Dogger Bank South Offshore Wind Farm

Appendix L to the Natural England Deadline 3 Submission
Natural England's comments and updated advice on Change Request 1

Planning Inspectorate Reference EN010125

19th March 2025

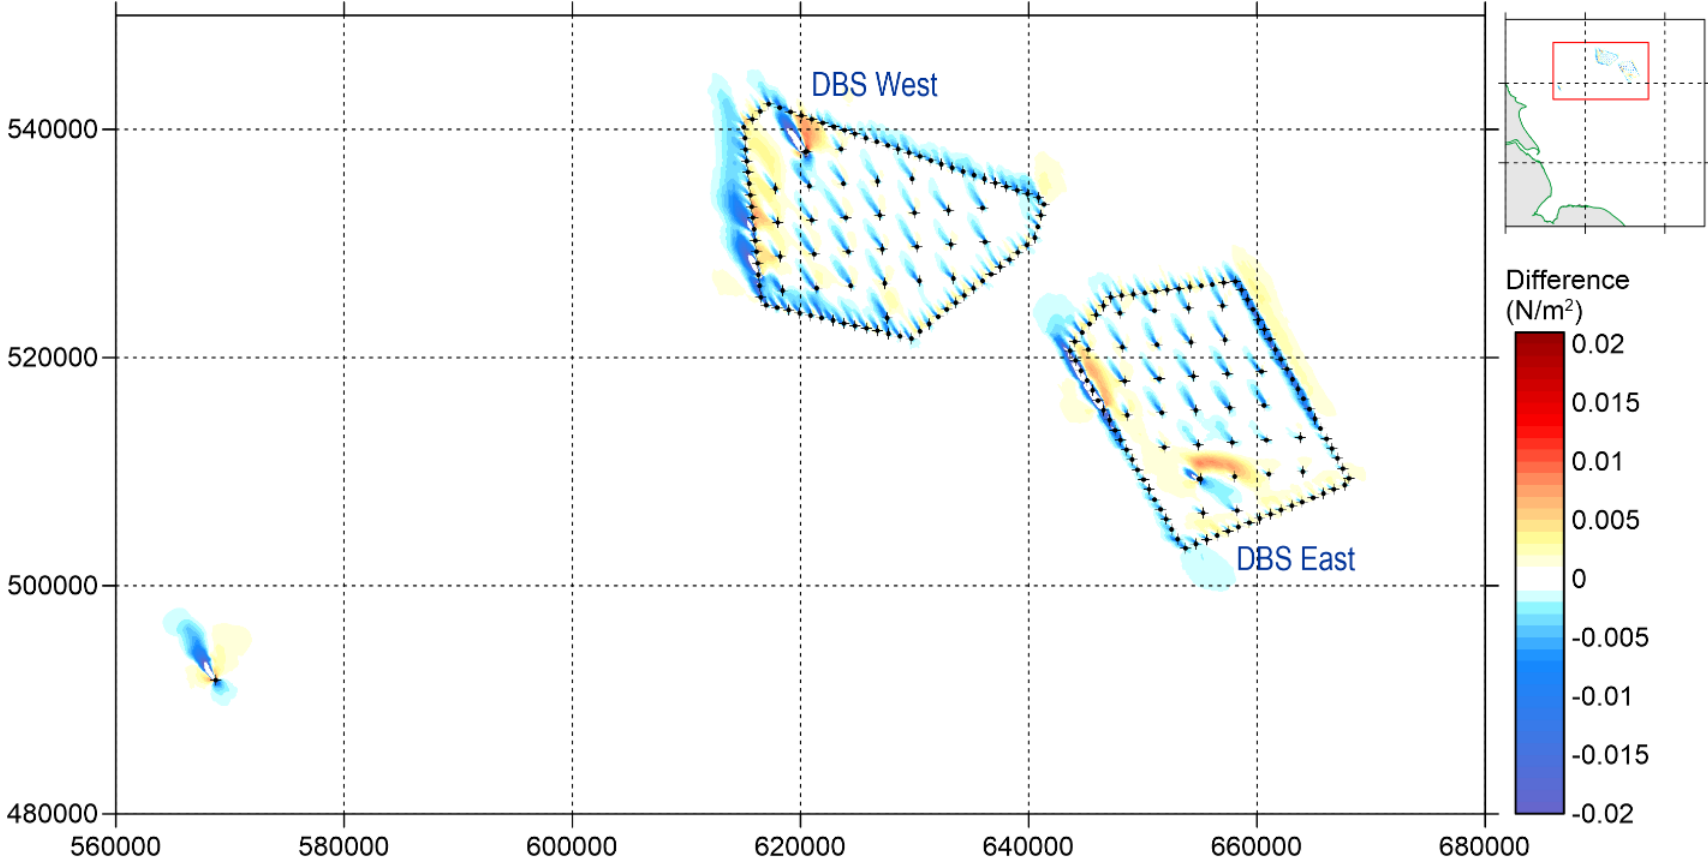
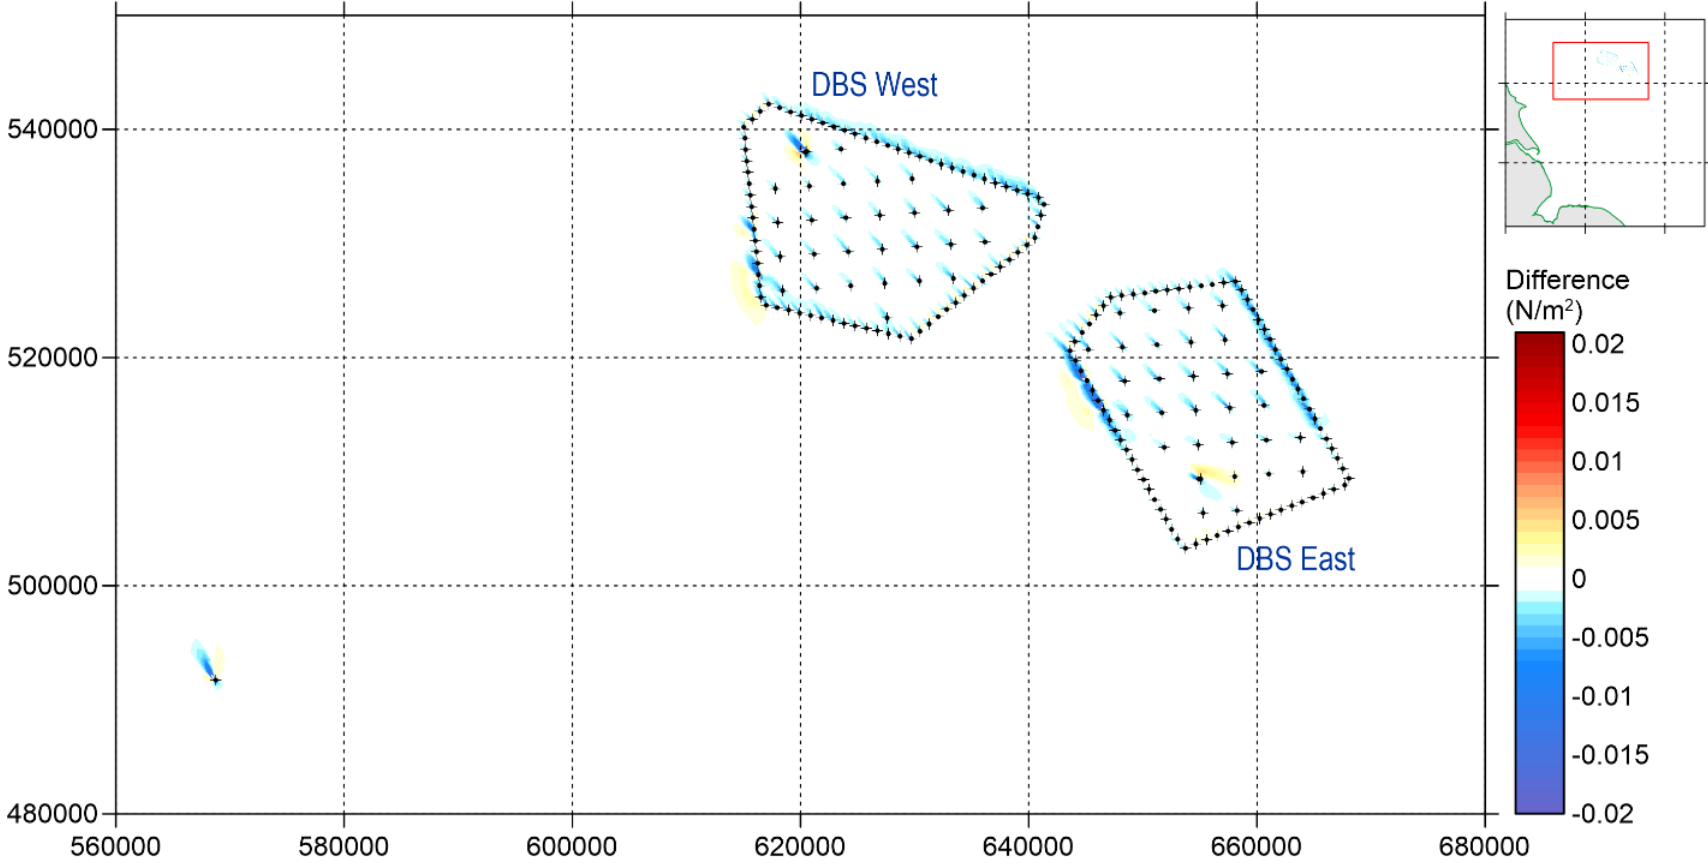
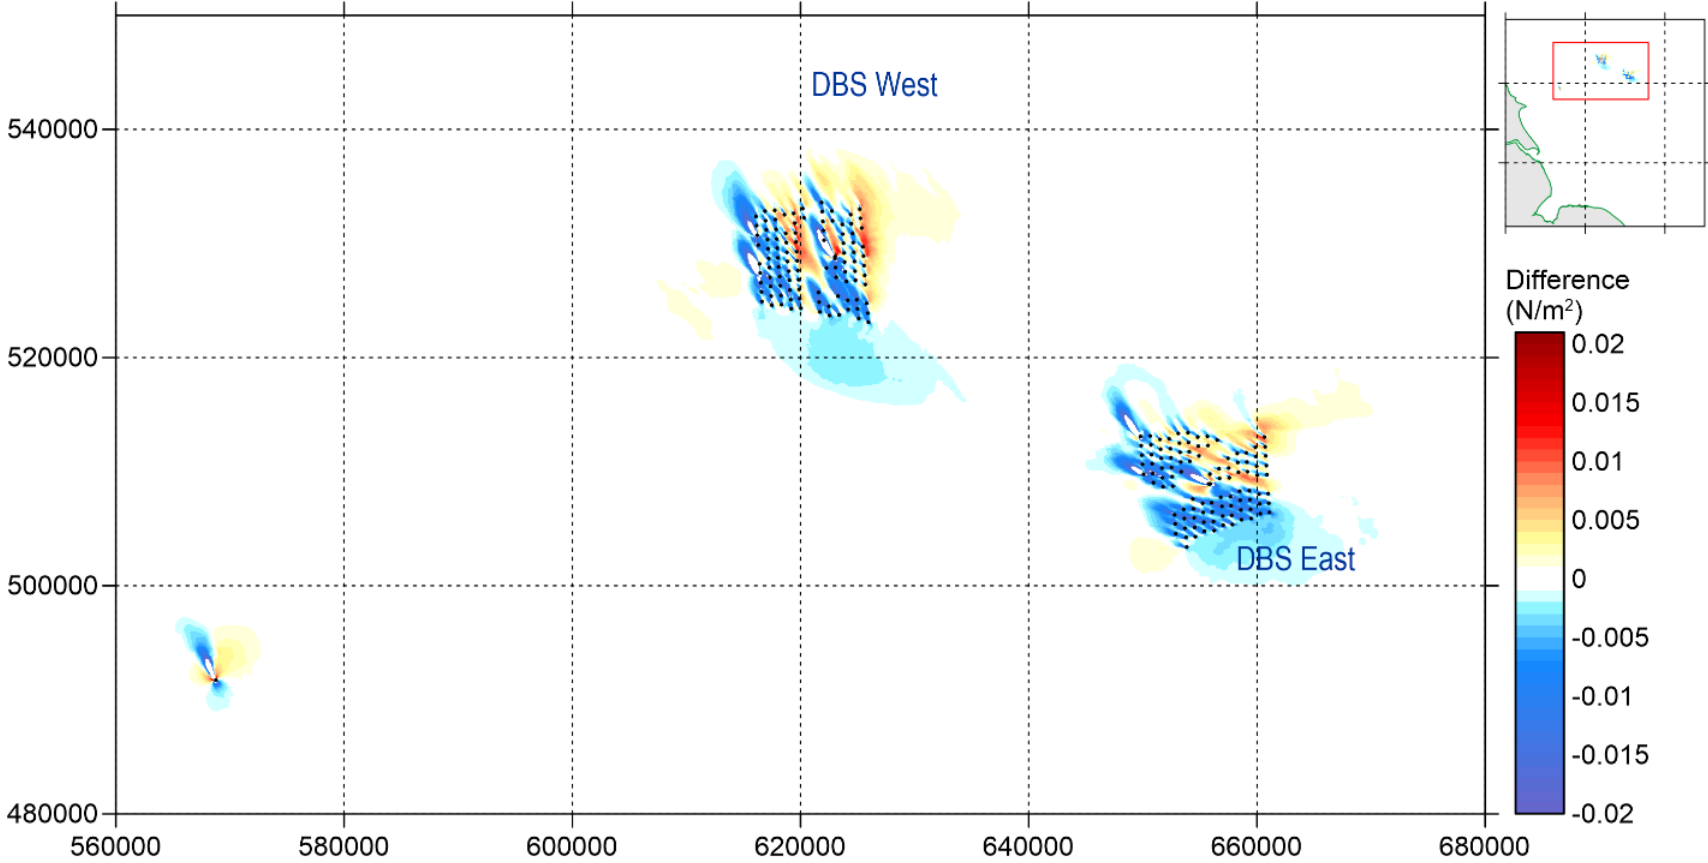
7	AS-136/ REP2-018	The contour plots in Annex C show distinct "shadow areas" of decreased or increased current speeds and	We continue to advise that the Applicant needs to consider impacts to Dogger Bank sandbank due to changes in the

NE Ref	Section	Key Concern and/or Update	Natural England's Advice to Resolve Issue
	Annex C	bed shear stress that extend from the arrays due to the presence of the DBS E and W arrays. Although it is stated that this could " <i>manifest as northwest movement of sandbanks and spatially varied seabed mobility within the Array Areas...</i> ", there is insufficient consideration of the potential lifetime implications for seabed mobility and morphology.	wave, hydrodynamic and sediment transport regimes [R&I, B19].
Fish and Shellfish			
Document used: [AS-142] 10.5 Appendix A – Fish and Shellfish Environmental Statement Update			
8	Section 1 Point 2	The Project has been updated to remove the electrical switching platform (ESP) in the export cable corridor (ECC).	Natural England welcomes the Applicant's request to remove the ESP, particularly for impacts to herring. And has no further comment at this time.
